## Notes of 2/15 MMC Site Plan Review Meeting (CMP/Detours)

Key points from the 2/15/18 Site Plan Review meeting with MMC:

### **Congress Street Closure and associated detours/emergency access (based on the revised docs and plans attached to this e-mail from Gorrill-Palmer)**

**CMP - East Tower and Visitor Garage (based on revised CMP as attached from Turners)**

- a. Week one – build crane.
- b. Week 2-7 – erect precast garage.
- c. Week 8 – dismantle crane.

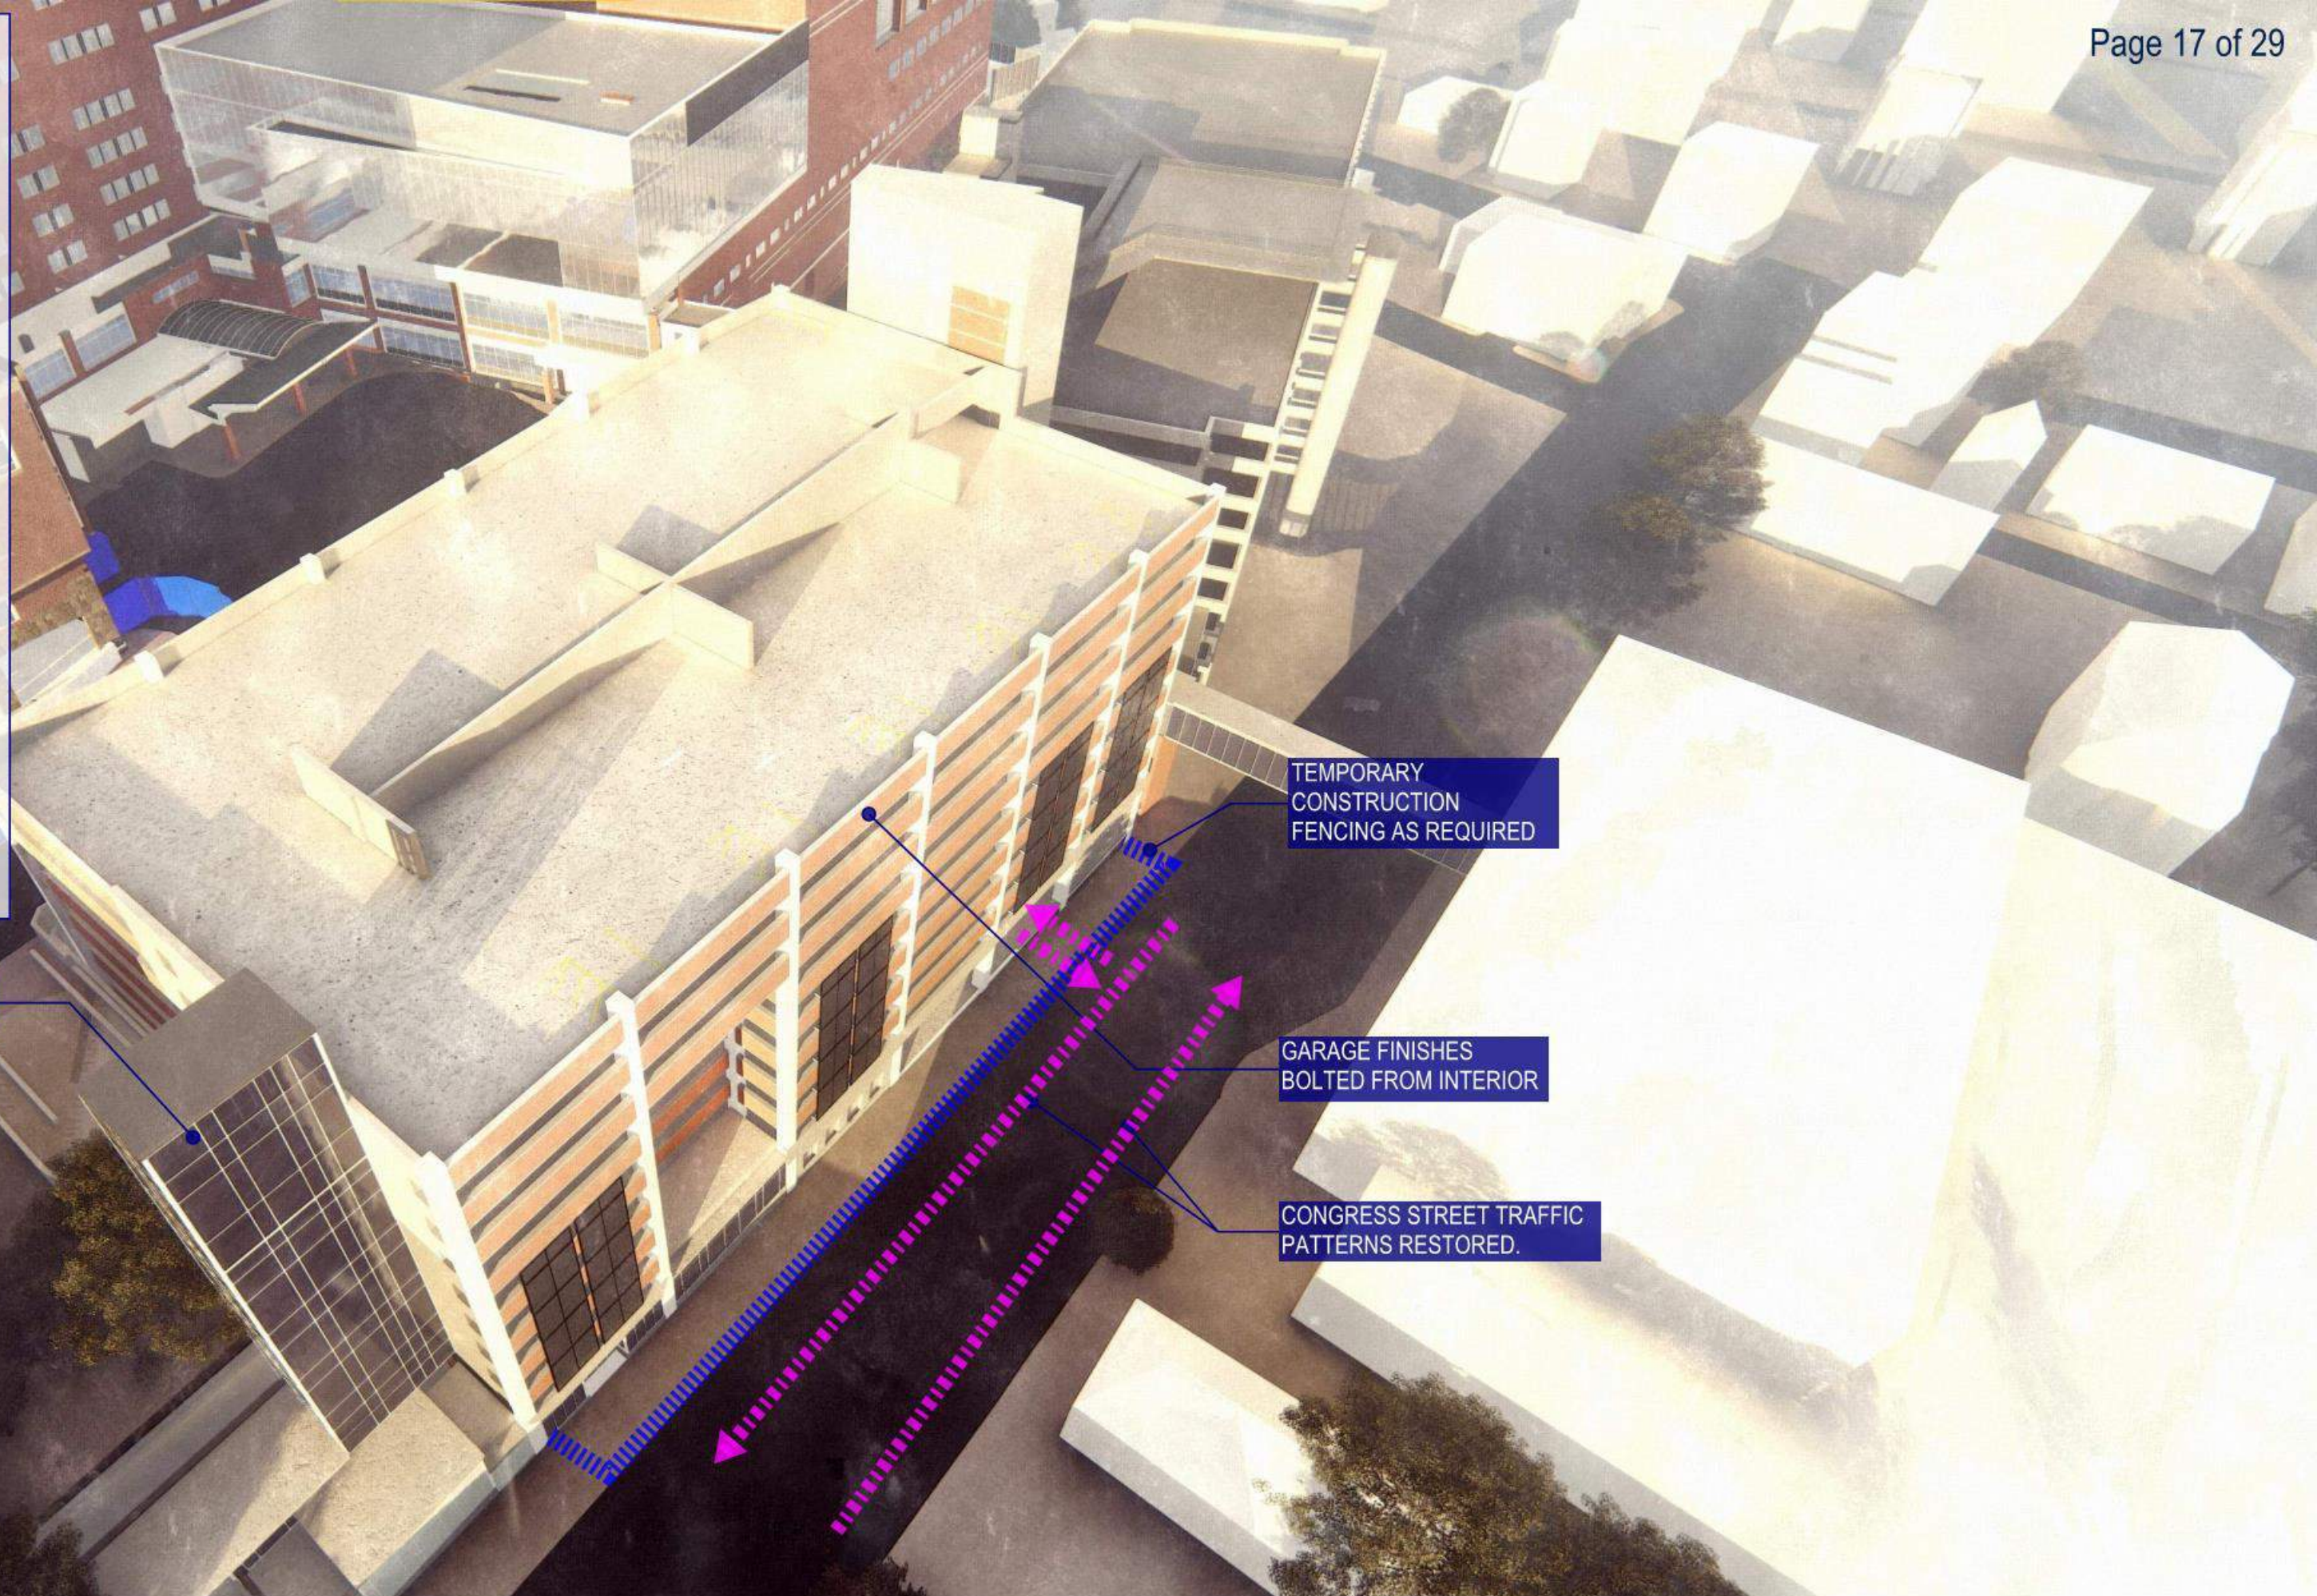
- Congress St closure anticipated May 7 to June 28 for the installation of precast beams for overbuild of the visitors garage - weather biggest factor
- Turner summarized the revisions to CMP, which included facilitating the ambulance access, adding delivery routes

- Concern re pedestrian route along Congress by construction area
  - Need ADA ramp
  - Need 9ft for crossing
  - Ensure entire sidewalk available

- Look at conflicts for peds crossing Weymouth at Congress - need to address
  - Gilman crosswalk needs to be ADA compliant
- Timetable (based on SO (Tuck) discussions with MMC and City Communication Directors)
  - - Need for early completion of telephone tree communication structure/contacts to be circulated within about 2 weeks and to be tested ahead by local and regional responders
  - - In week after 2/27 PB meeting need schedule that includes lead time and actions
  - - Early prep of handouts for employees and visitors plus early website info important

Congress Street Detour

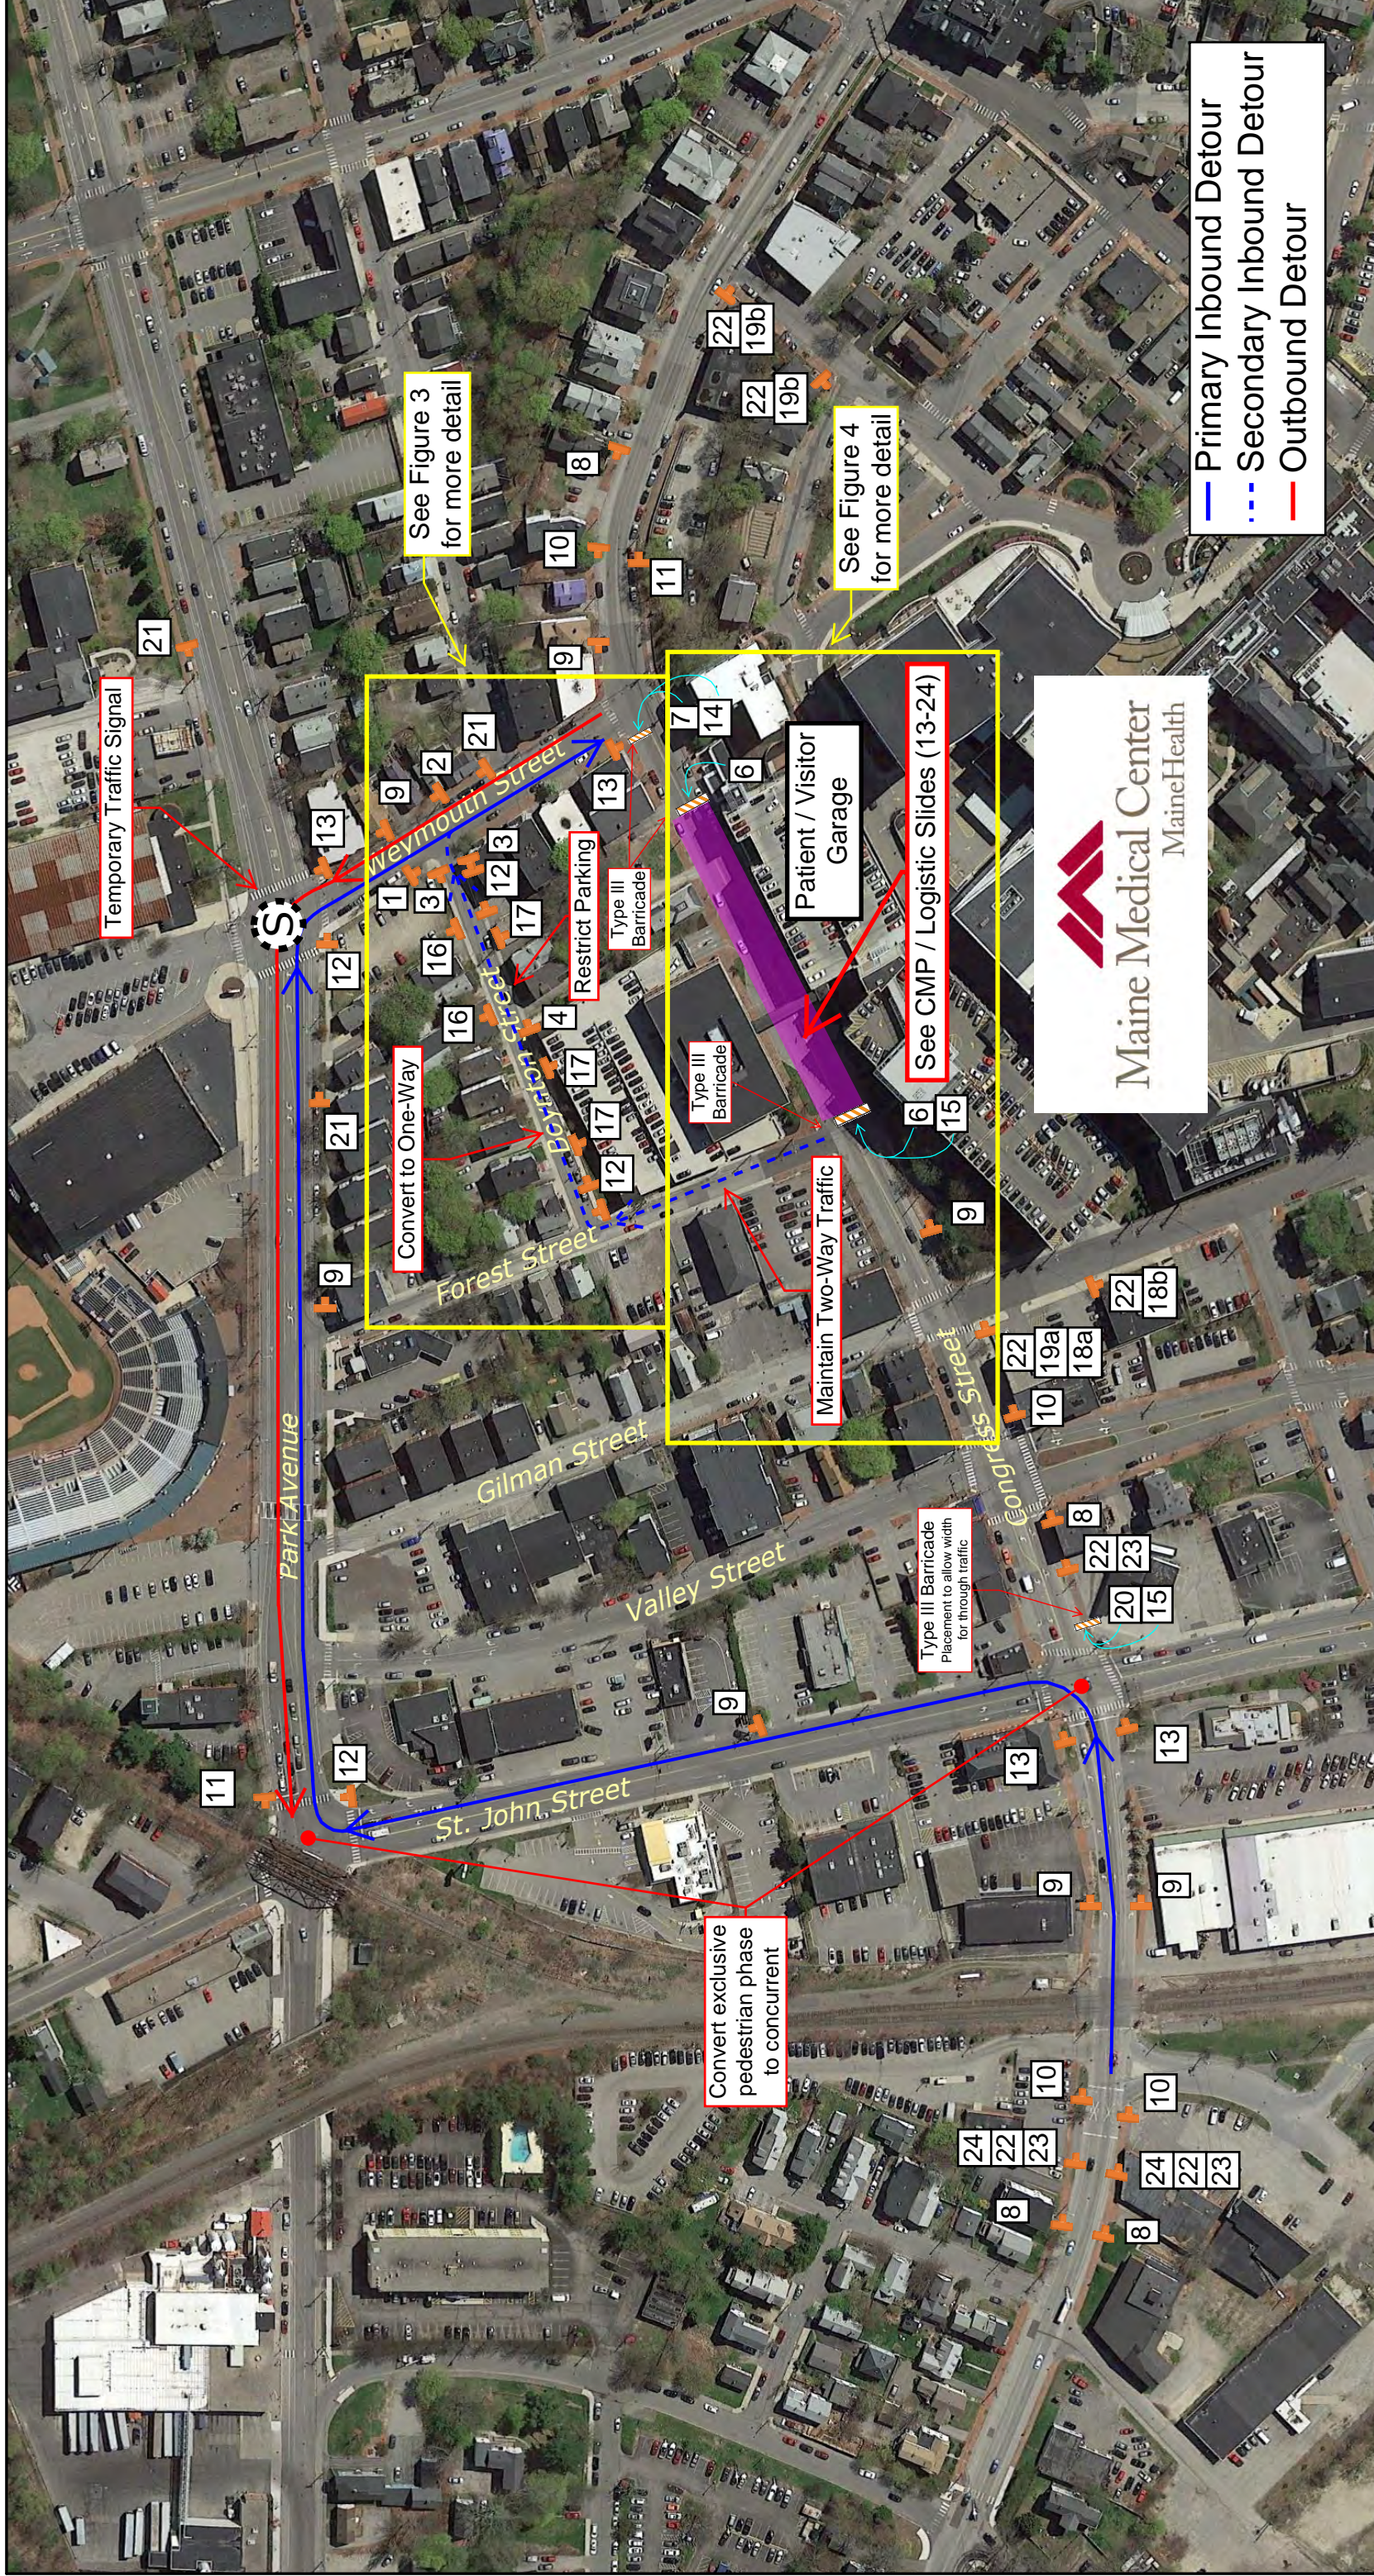
- RD of GP had developed the option with Boynton one-way inbound, based on feedback from earlier meeting
- Outlined the "three-layer" approach:
  - Signage via variable message signs outside central Portland to encourage different routes into the City
  - Barricades at Congress/St Johns and at Weymouth/Congress to re-route the bulk of traffic
  - Local traffic may use Forest/Boynton inbound
- Outlined the changes needed for each of these (see plans) eg signal at Weymouth/Park (actuated); removal of parking in addition to signage; change ped to concurrent crossing in some places (but RD thought signal timing otherwise OK)
- Key concerns (need more analysis and discussion):
  - Police particularly concerned re the safety of retaining central lane at Congress/St John - rather see it removed even though a number of cars going straight ahead

- Emergency Routes (see plan)
  - Clarified that access via Gilman only secondary and only when the "green" route is closed
  - Attendees stressed need for communication and decision-making chart

Maine Medical Center - Garage Access During Congress Street Closure

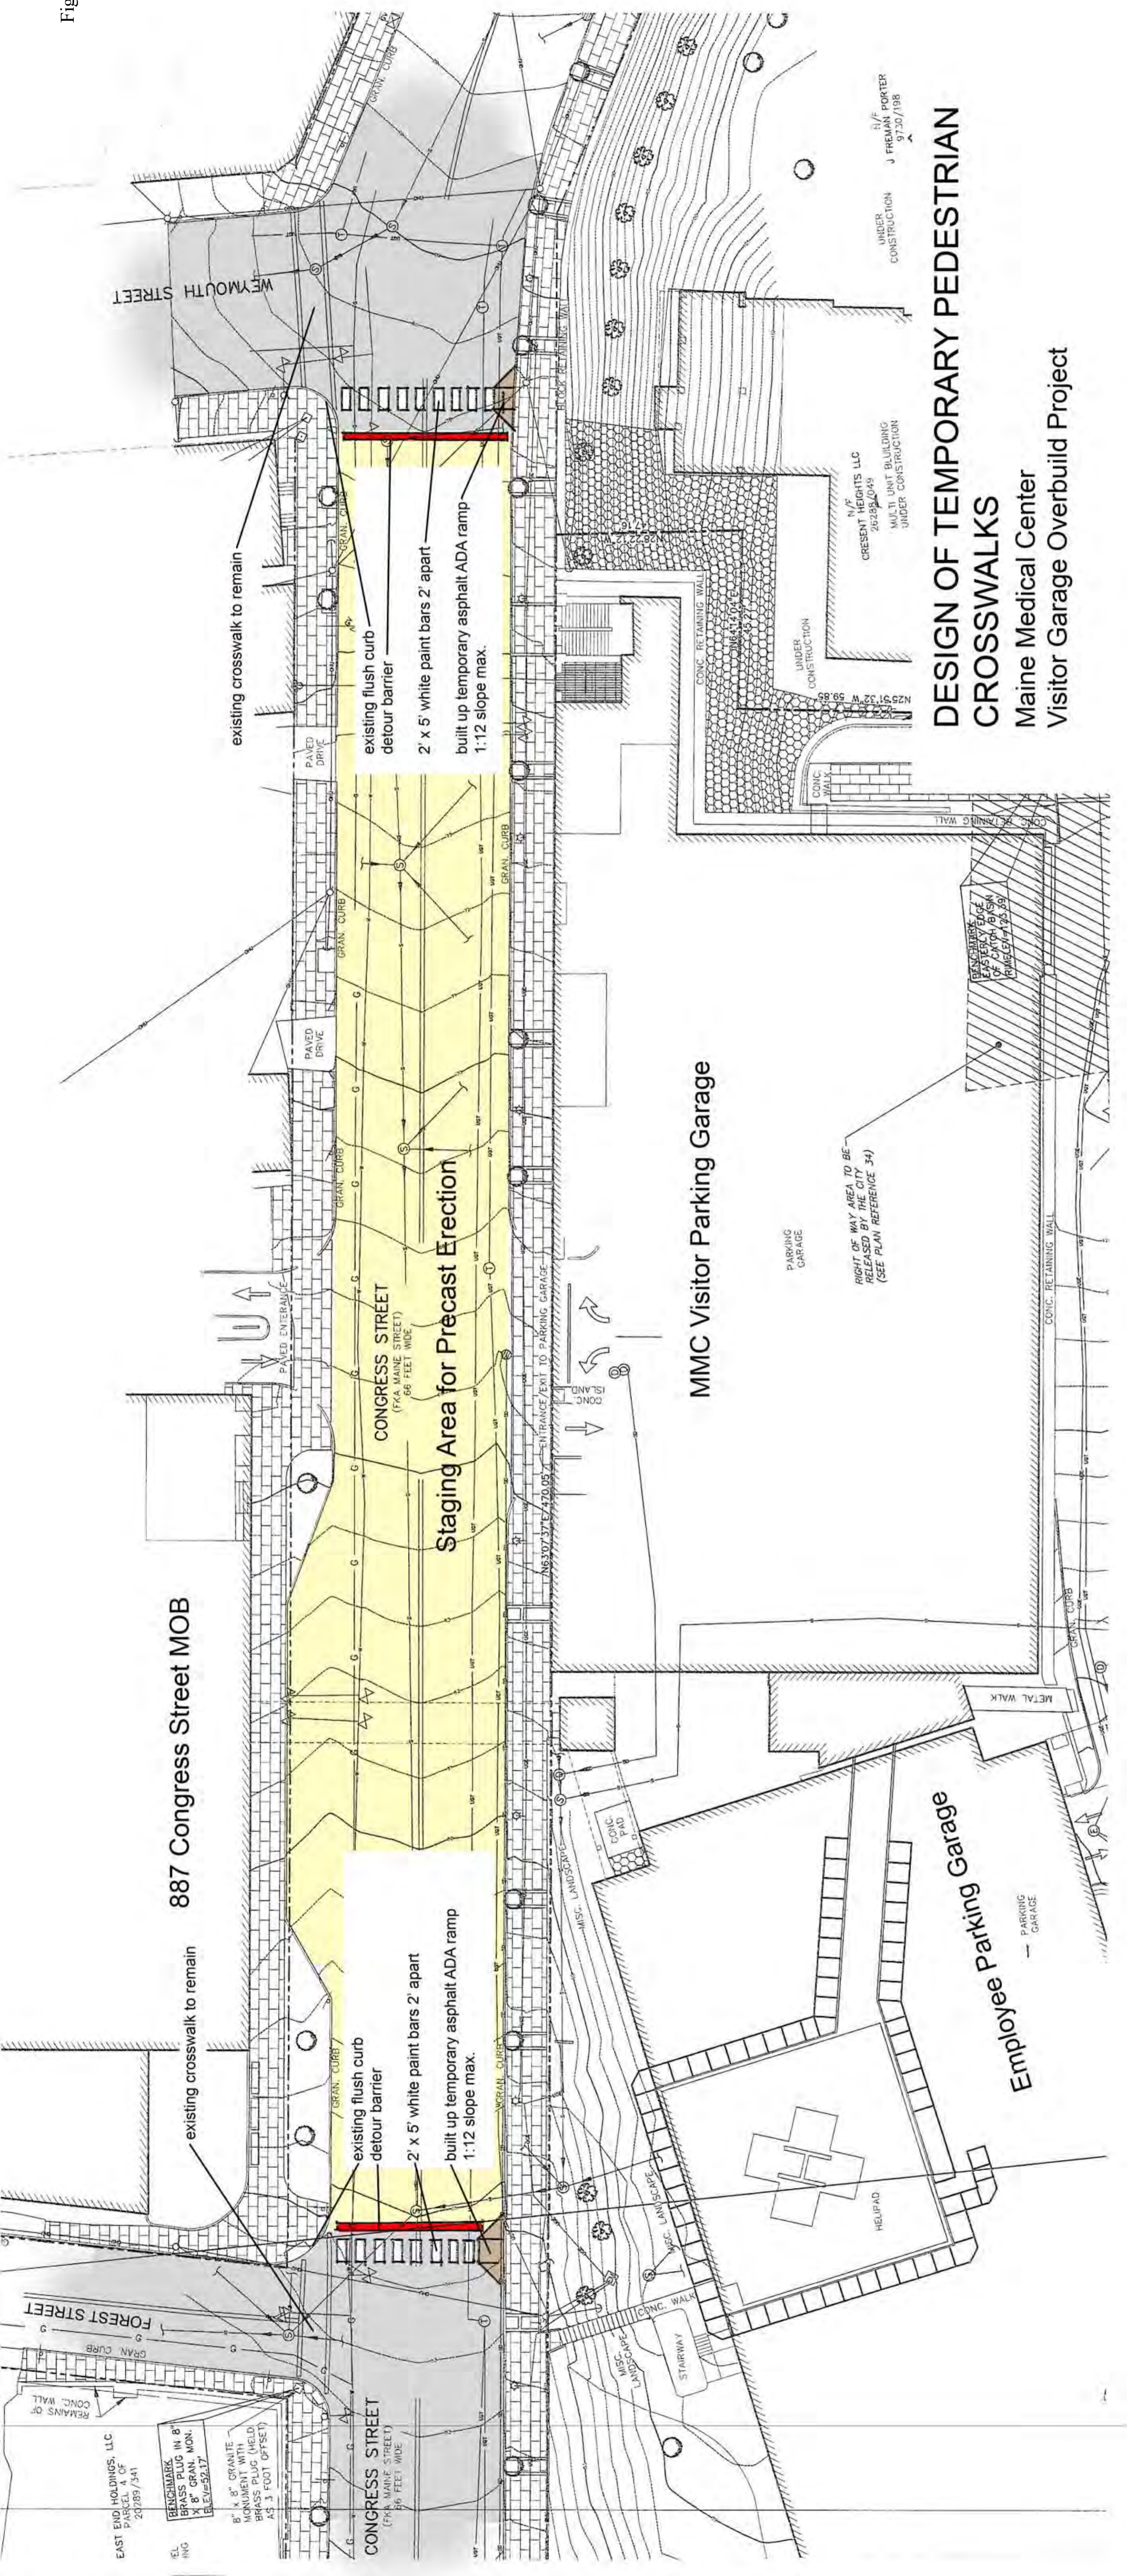
- Consider impacts on residents and businesses of some routes and semi-closures
  - Introduce Boynton as one-way working a couple of weeks in advance
- Access to visitors garage during Congress closure (see plan)

- Via employee garage, channeled and flaggers as needed
  - 200 employees moving out of the employee garage to make up for loss of 2 levels in visitor garage during construction
